CITY OF PORTLAND

Located At 24 TORREY ST

Job ID: 2011-07-1749-SF

has permission to build a new Single Family Residence.

**A.3**

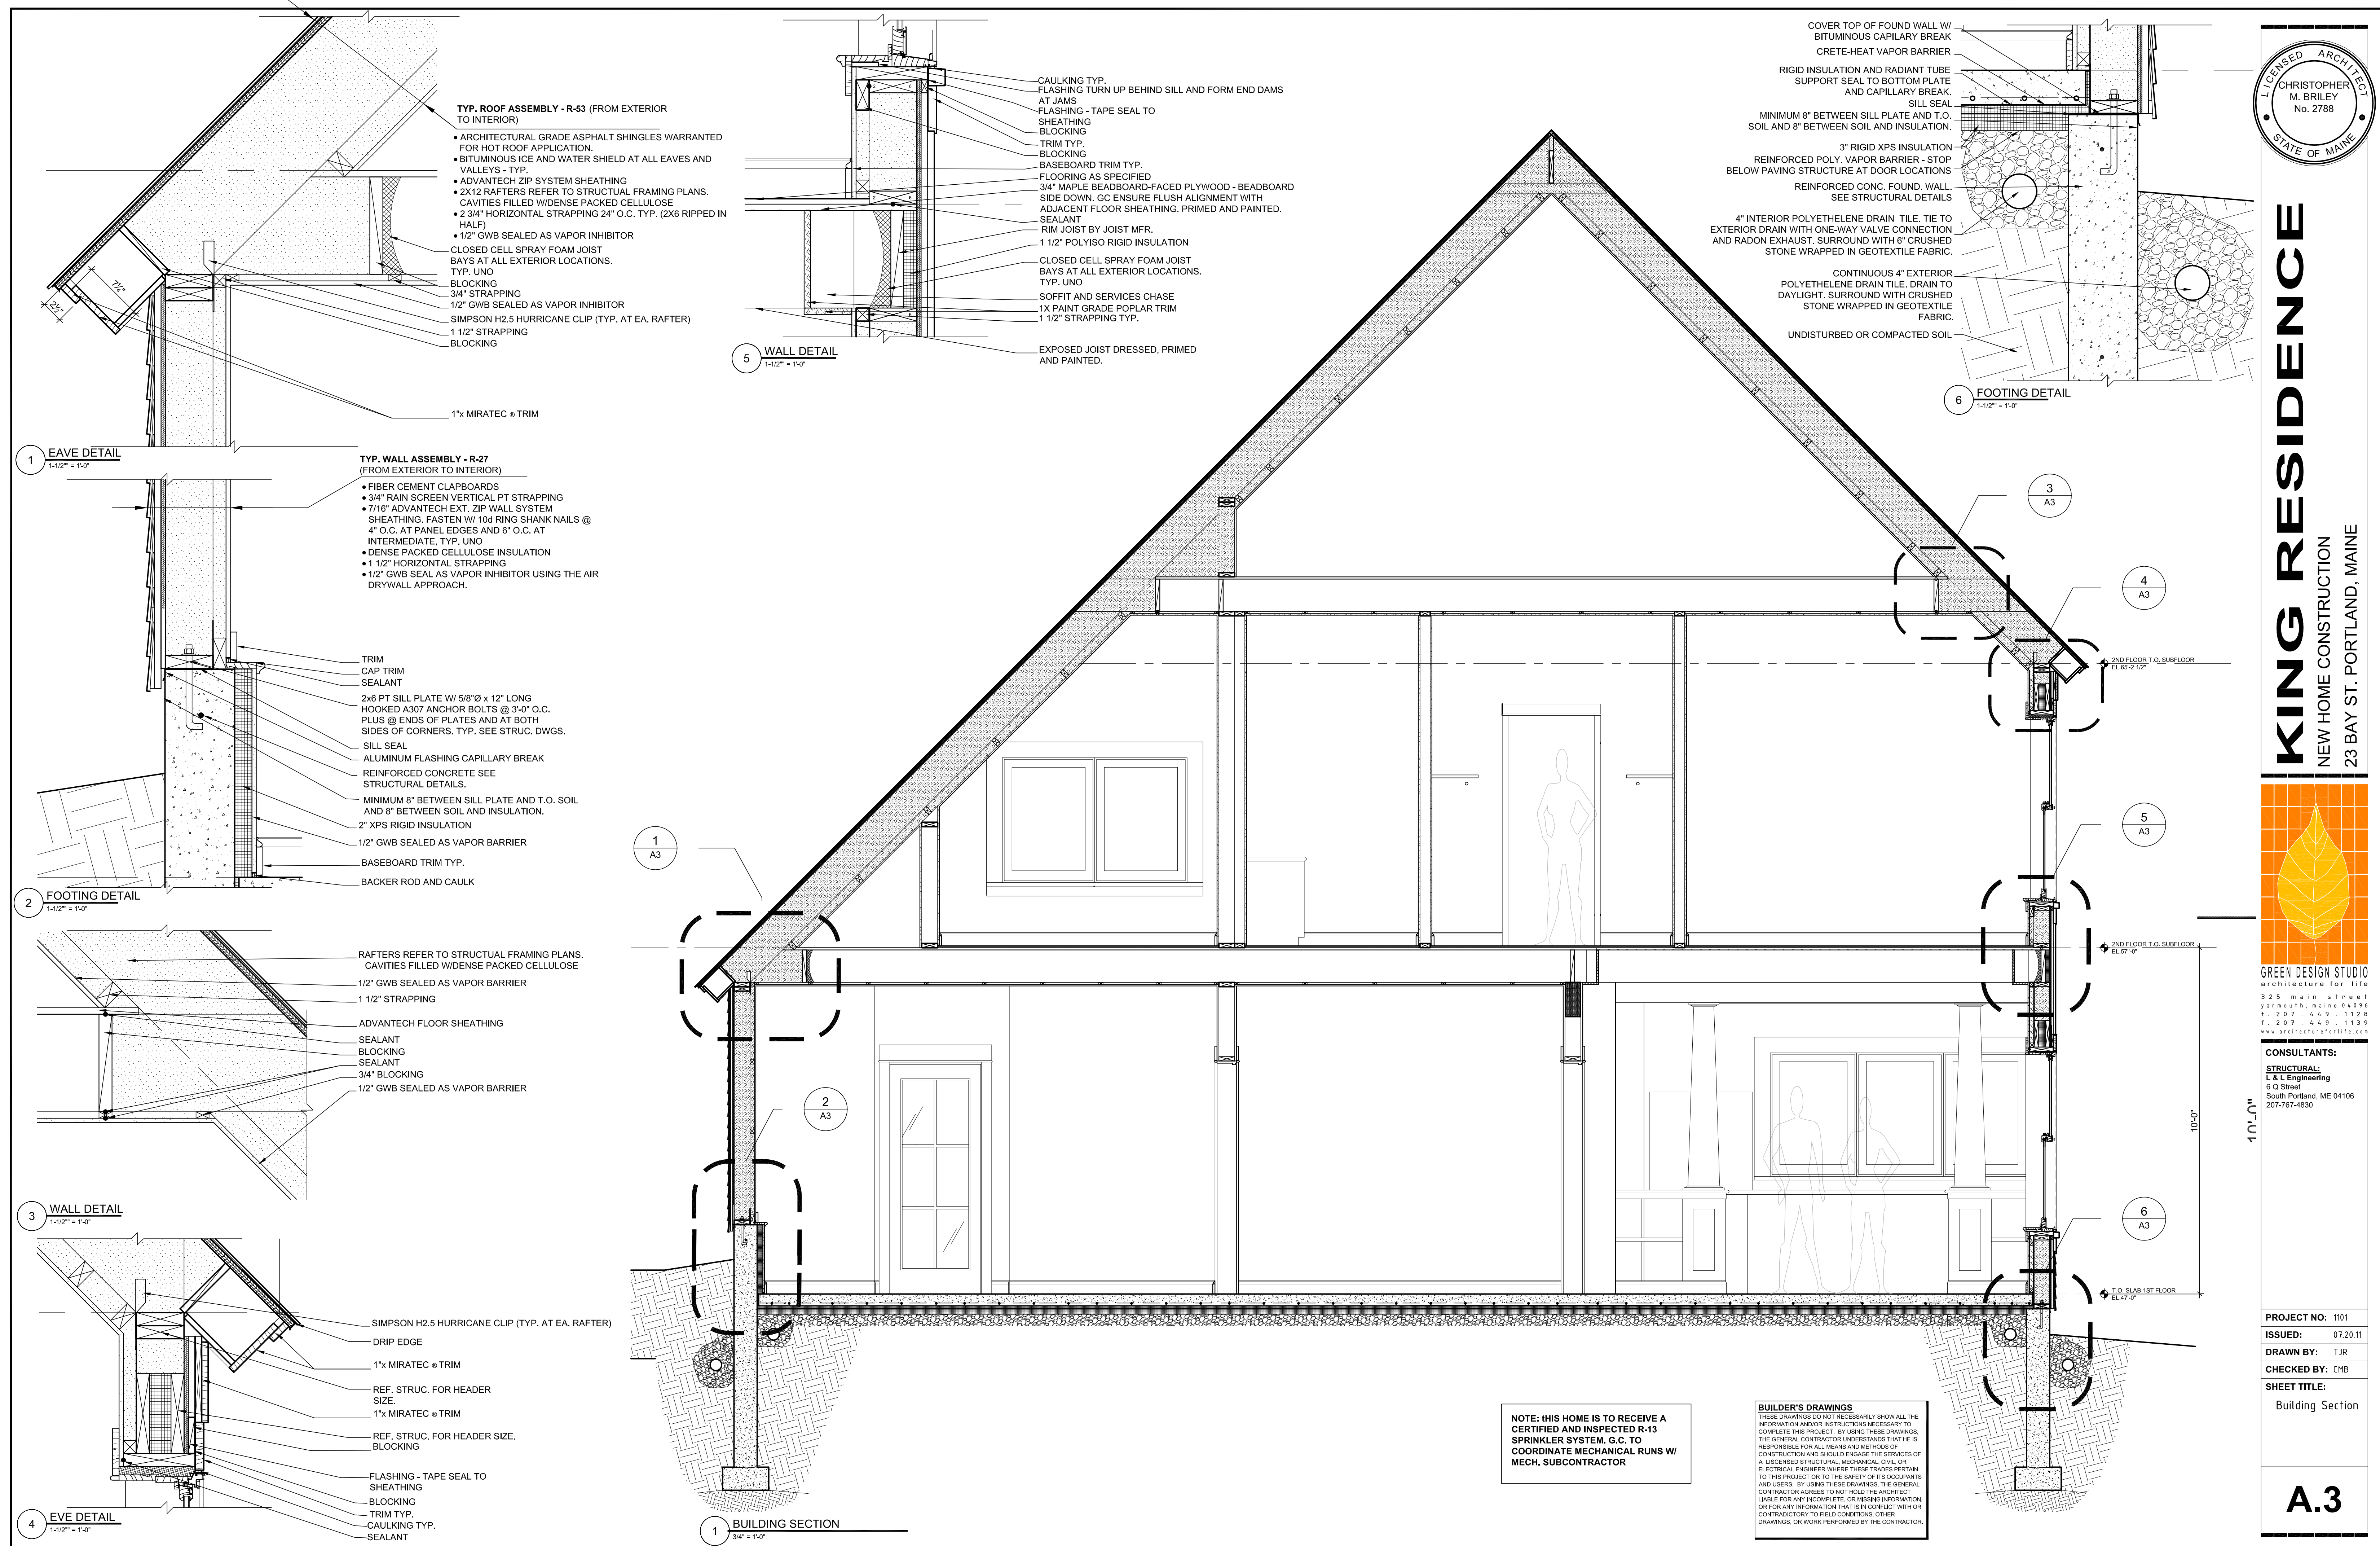
Building Envelope/ Energy Efficiency must comply with MUBEC

Typical R- values are as follows (and stated on the drawings, Sheet A.3). Rafters 53, Walls 27. The Slab has 3" of Rigid Extruded Polystyrene Insulation R=16.5. The Floor of the conditioned space over the garage has an R-value of 45.6

**PROJECT NO:** BRILEY  
**ISSUED:** 07.20.11  
**DRAWN BY:** CMB  
**CHECKED BY:** ---  
**SHEET TITLE:**  
Foundation Plan  
1st Floor Framing

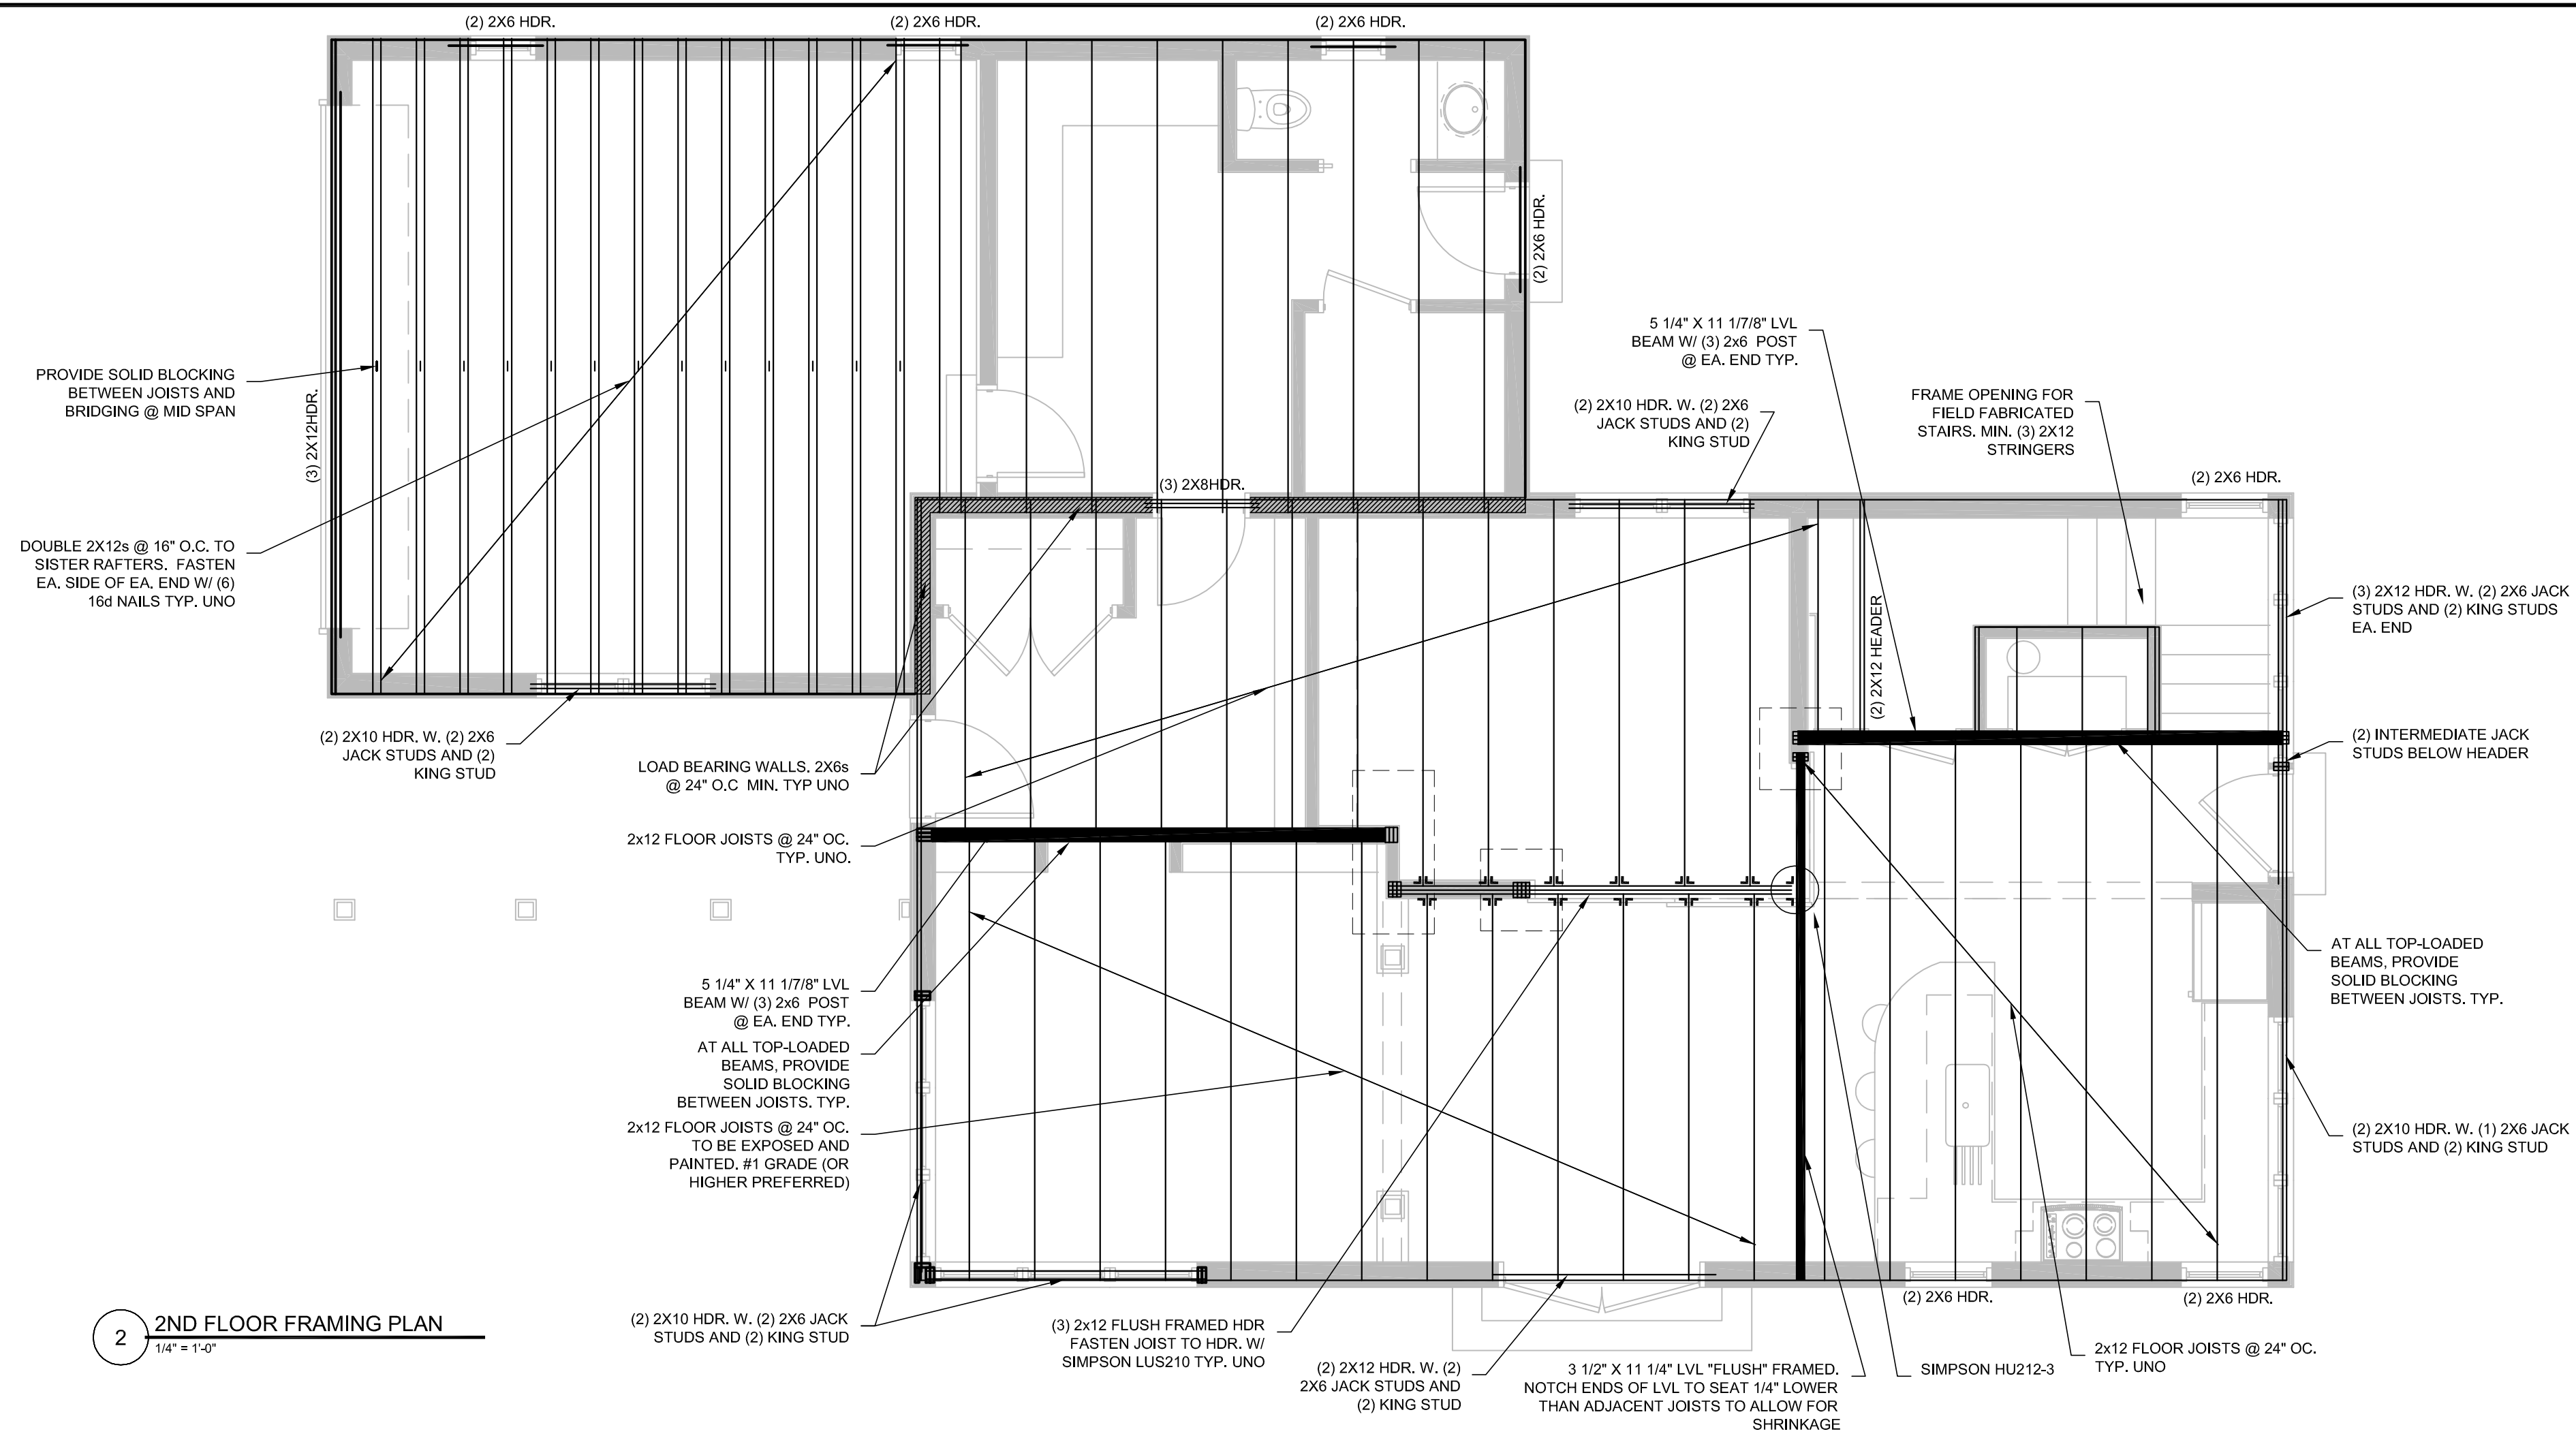
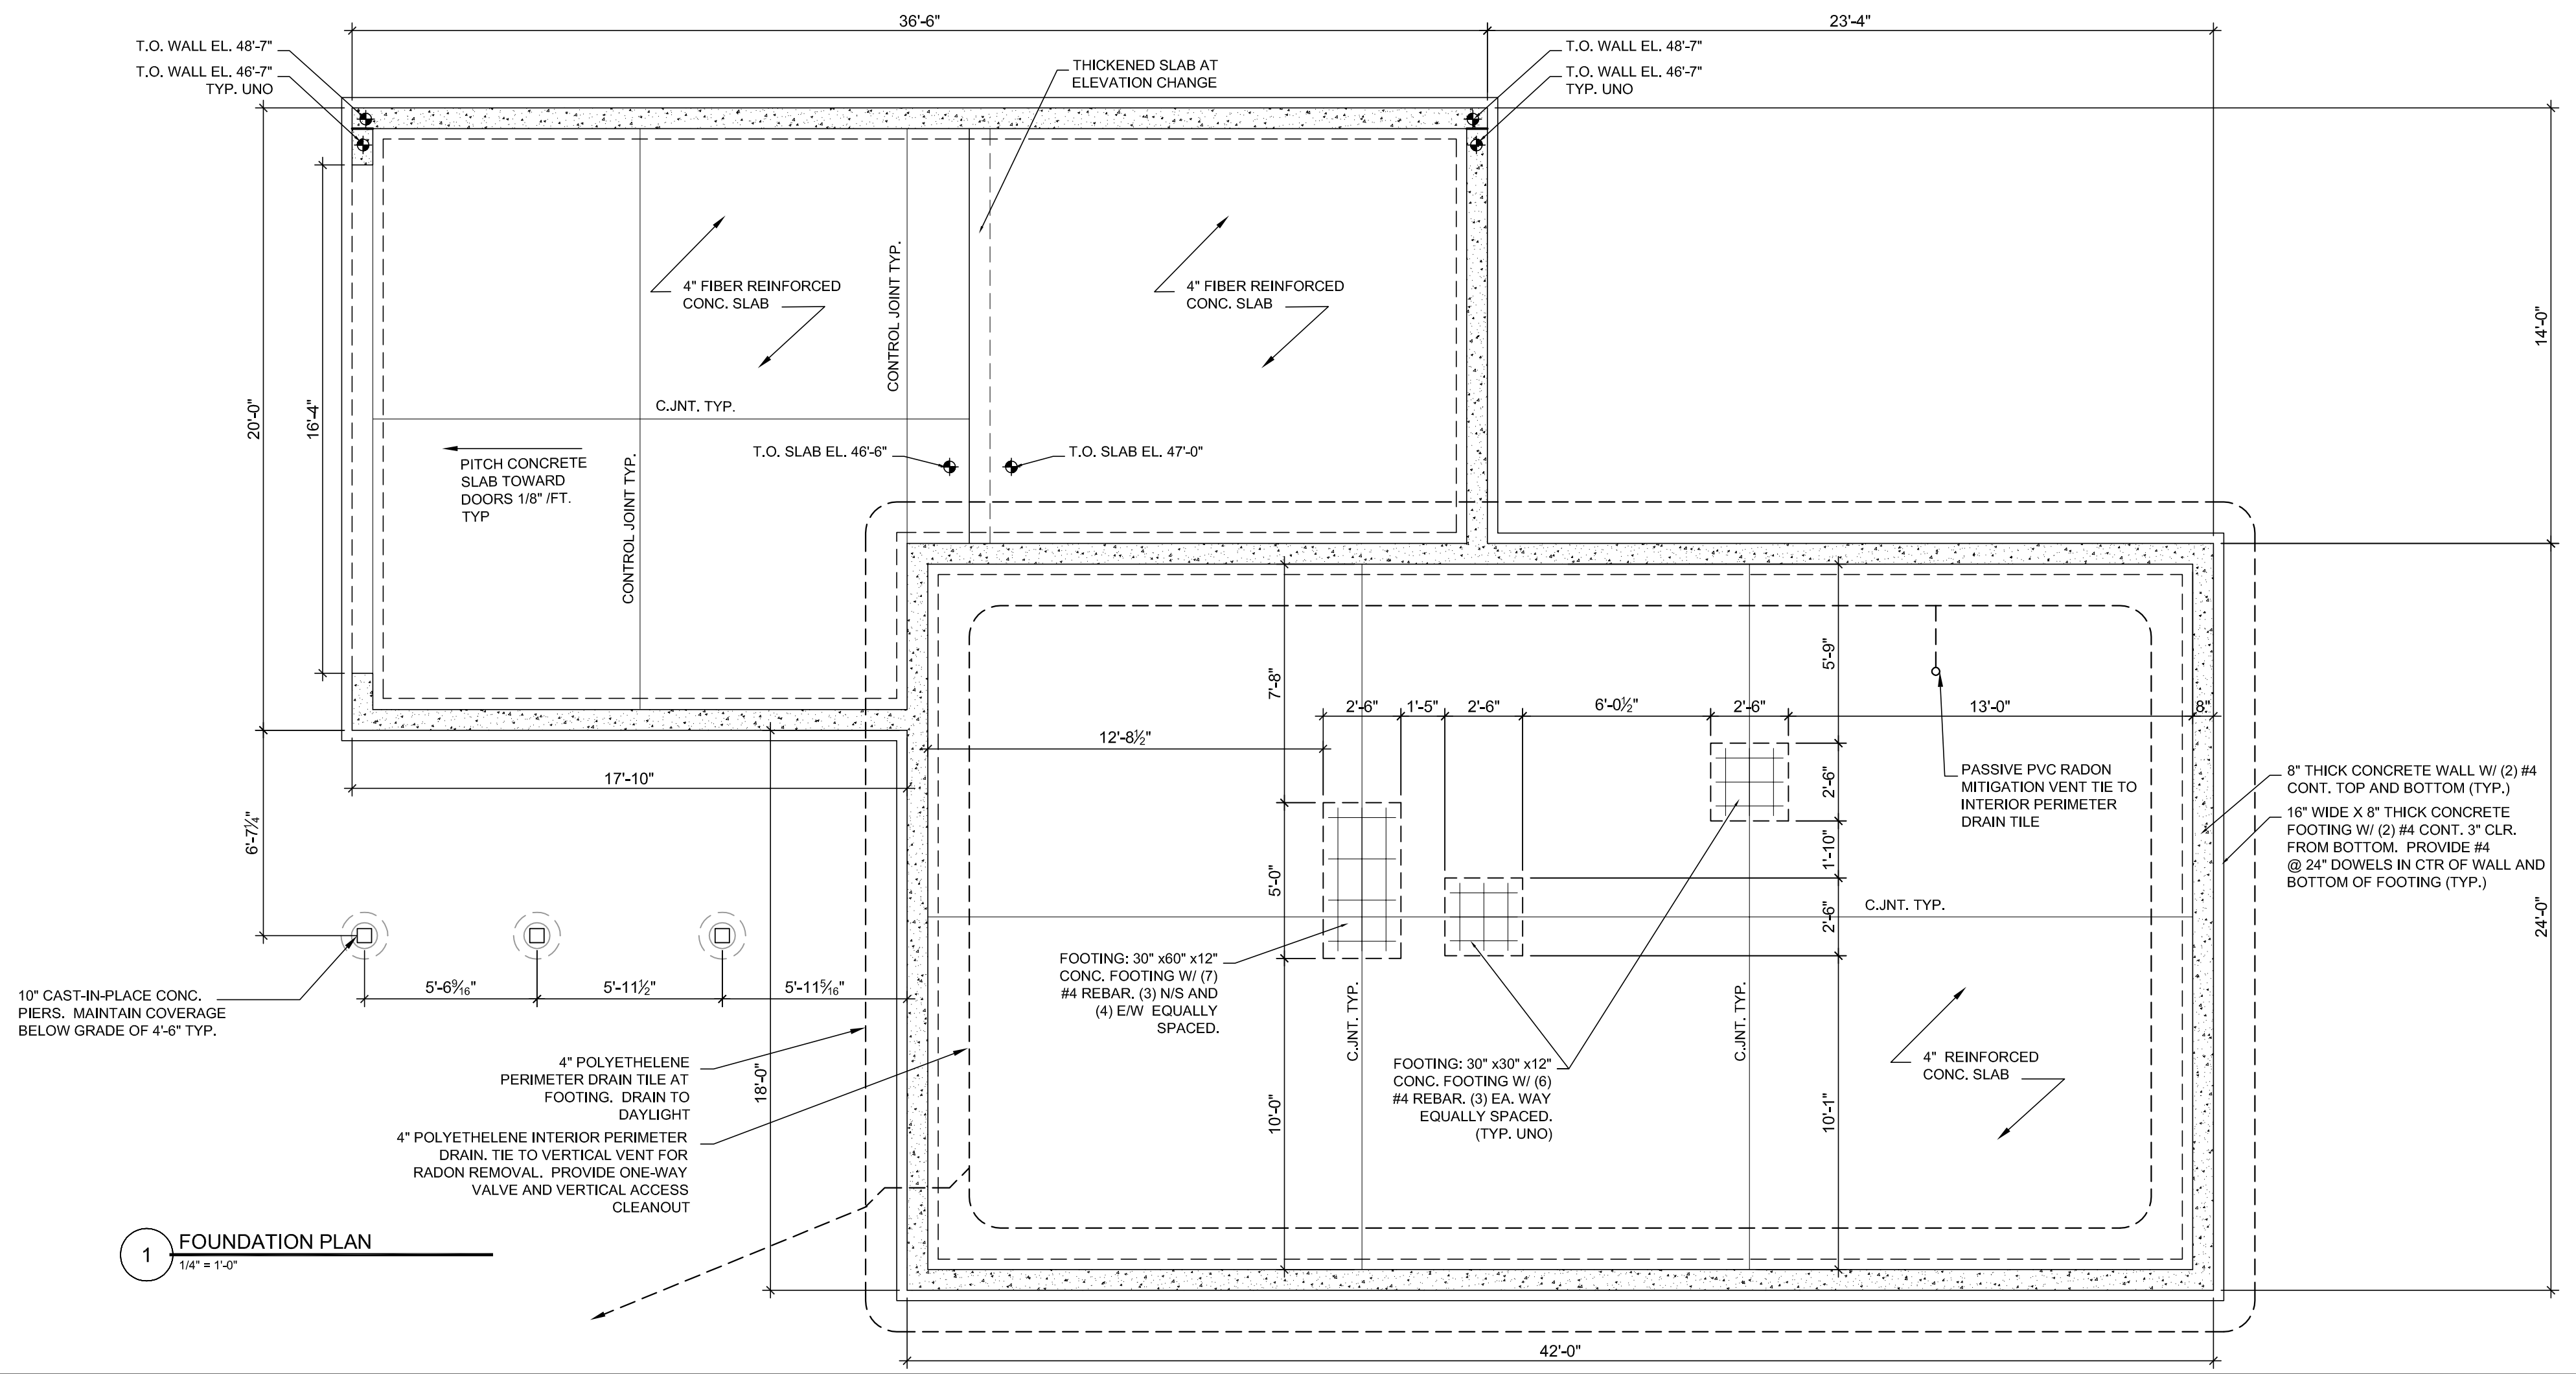
Fastener Schedule (Table R602.3(1) & (2))

Yes. At a MINIMUM the GC must fasten all structural members in accordance to the table R602.3(1) & (2) with the exception of the wall sheathing which shall be fastened with 10d nails at 3" O.C. at panel edges and at 6" O.C. at intermediate, minimum.
